Engineers Comments Regarding Surface Water Drainage

Application Reference:	FP/10/26/DOC	Reviewer Reference:	ADC/EXT5/AF
Planning Officer:	Daniel Vick	Date of Review:	16/02/2026
Site Name:	Land off Stanhorn Grove Felpham PO22 8FA		
Application Description:	Approval of details reserved by condition under FP/32/25/S73 relating to conditions 6 & 7 - drainage.		
Assessment Number:	1

Response	Condition 6: Objection
	Condition 7: Further information required

DRAWING TITLE
Drainage Layout

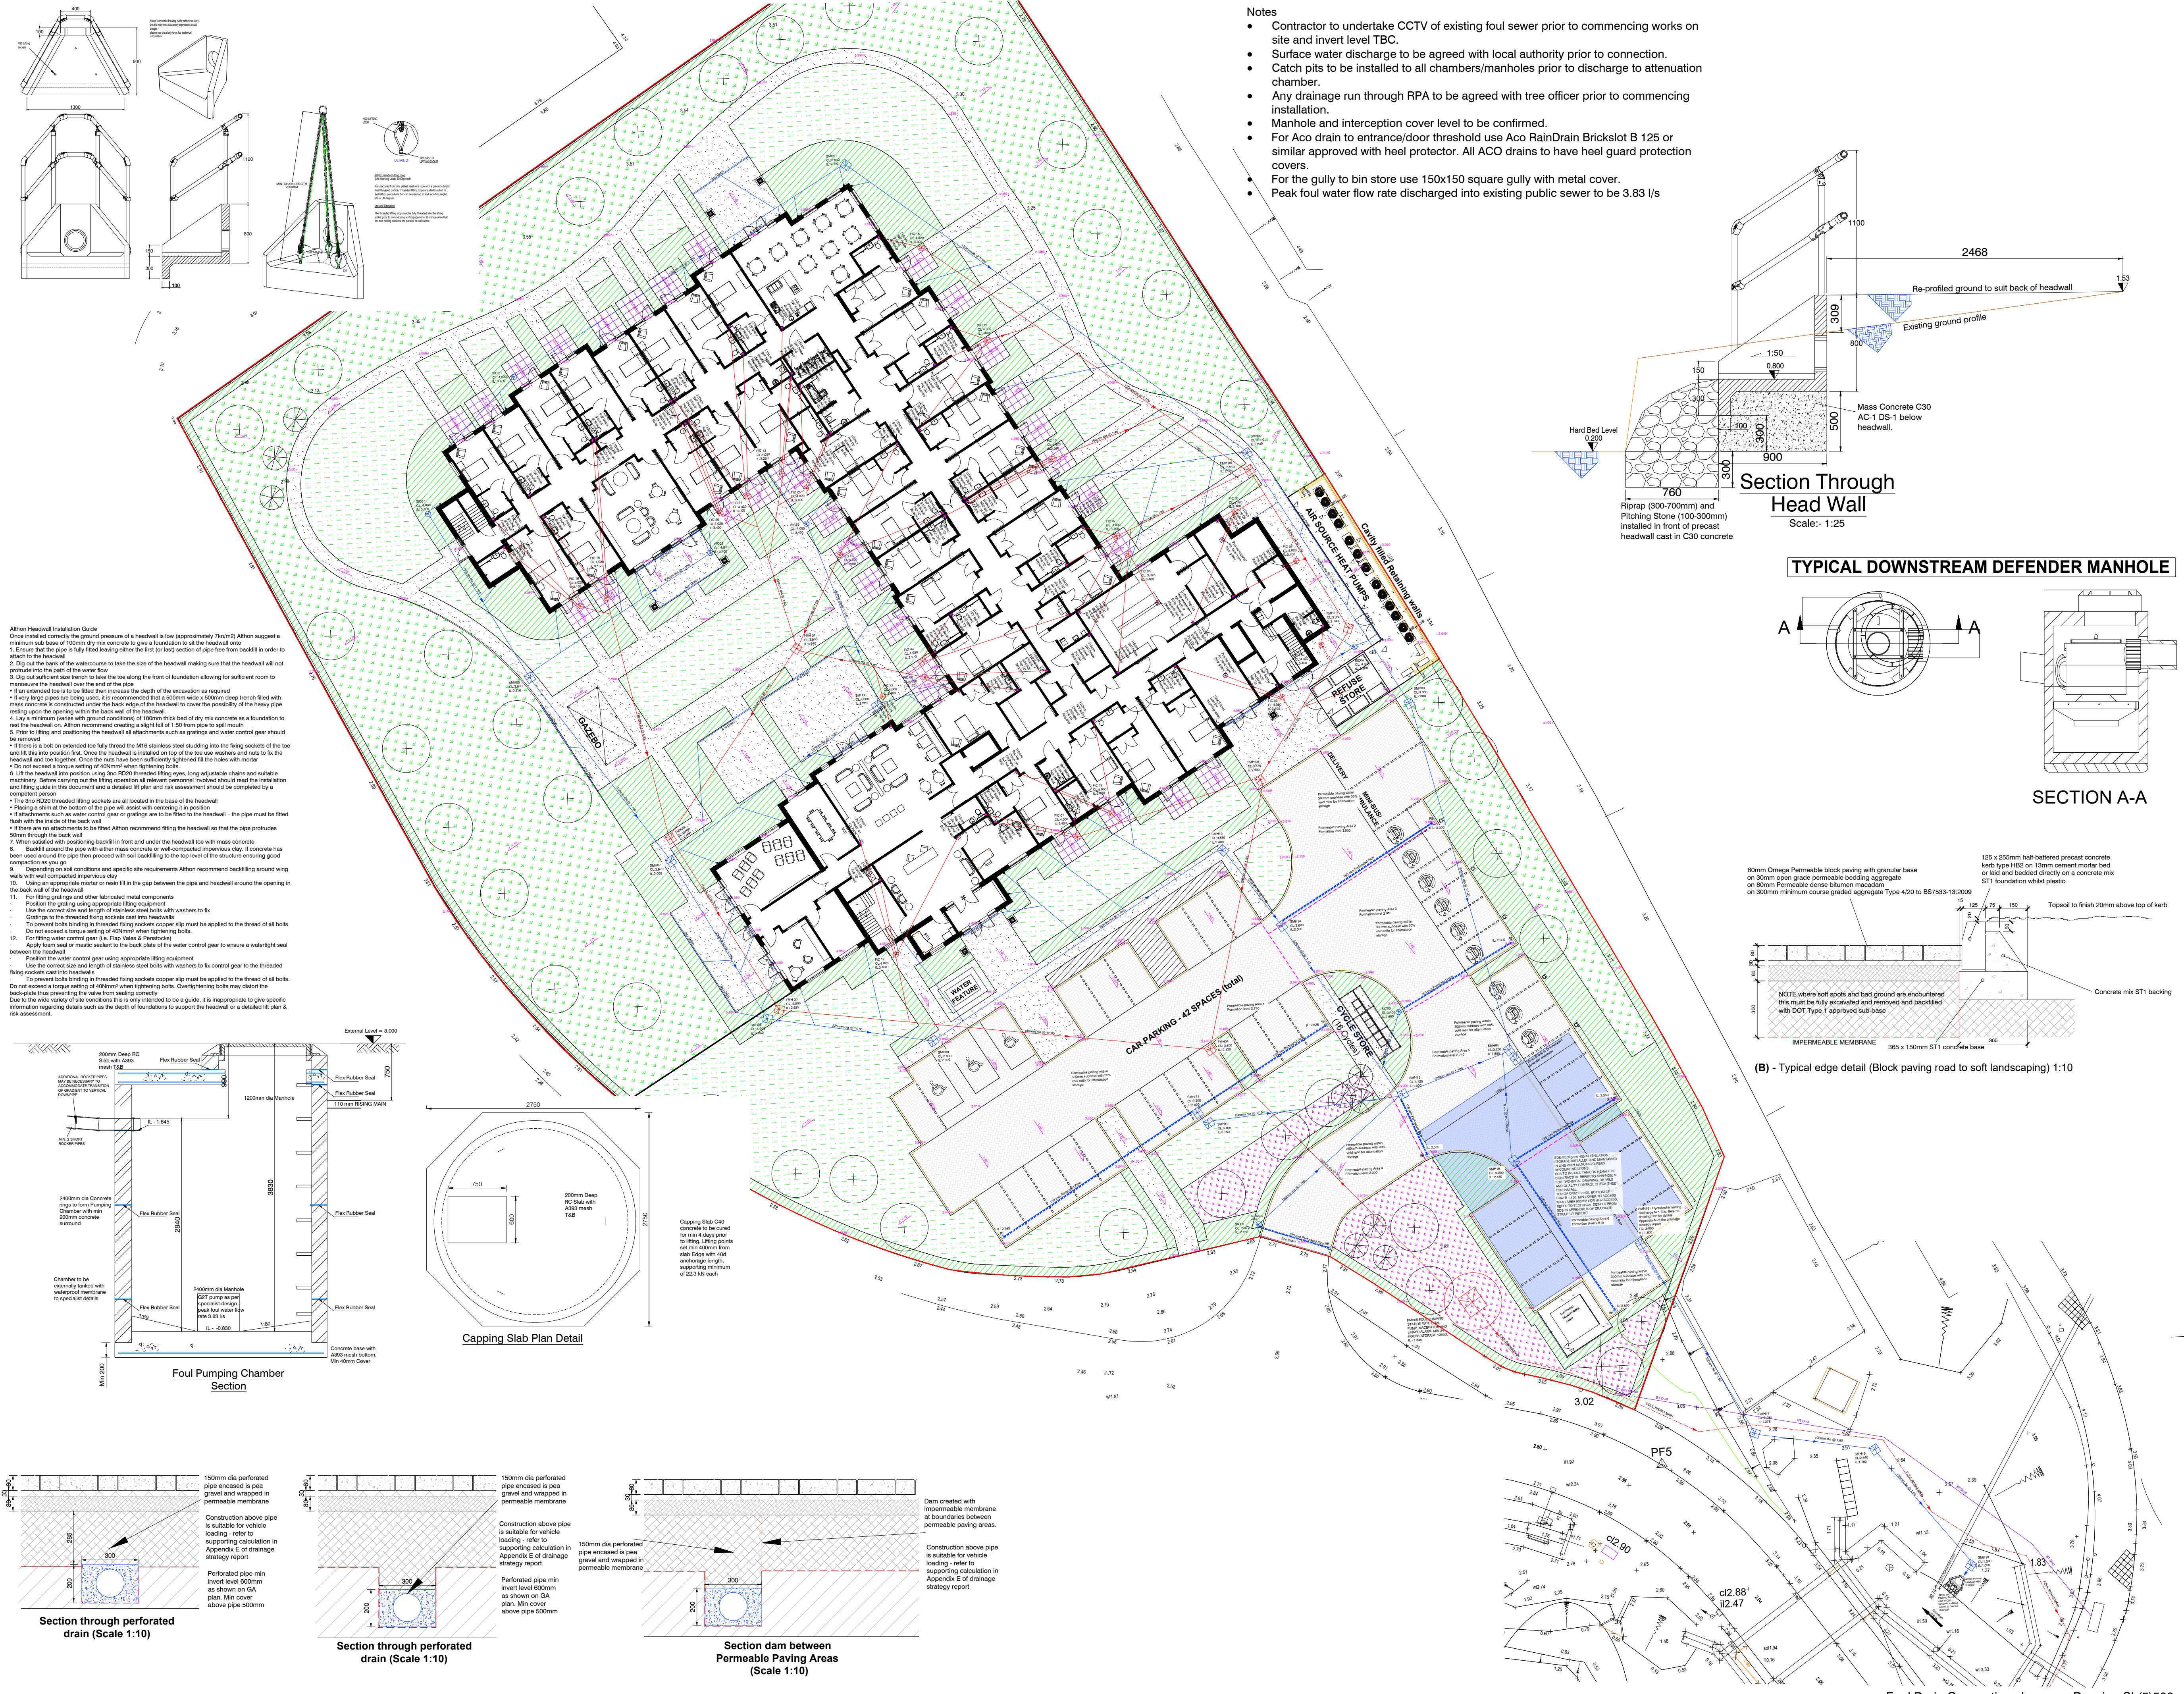
of the proposed soakaways should be provided during winter or spring months.				
3	Construction details should be provided for all drainage elements including the permeable surface paving and the soakaway.	See updated drawings I Appendix F	A construction detail should be provided for the flow control chamber.		
4	The drained areas are listed as a total of 3,878sqm whereas the calculations only include 0.327ha.	See updated report and additional drawing in Appendix F showing drained areas	Revised impermeable drained areas acceptable, comment closed.		
5	The proposed soakaway is designed using a factor of safety of 1 which is not in accordance with the NSIS.	Soakaway no longer proposed	Noted, comment closed.		
6	The calculations do not use the latest rainfall data. Site specific FEH data should be used and the data location coordinates confirmed.	Calculations updated accordingly as shown in Appendix E.	Noted, comment closed.

7	The CV values should be 1.0.	Calculations updated accordingly as shown in Appendix E.	Noted, comment closed.		
8	The Climate Change Allowance should be 45%.	Calculations updated accordingly as shown in Appendix E.	Noted, comment closed.		
9			Additional comment. The revised drainage strategy includes offsite private drainage infrastructure and an offsite outfall to an ordinary watercourse. Evidence should be provided of land ownership, or legal ability to install and maintain
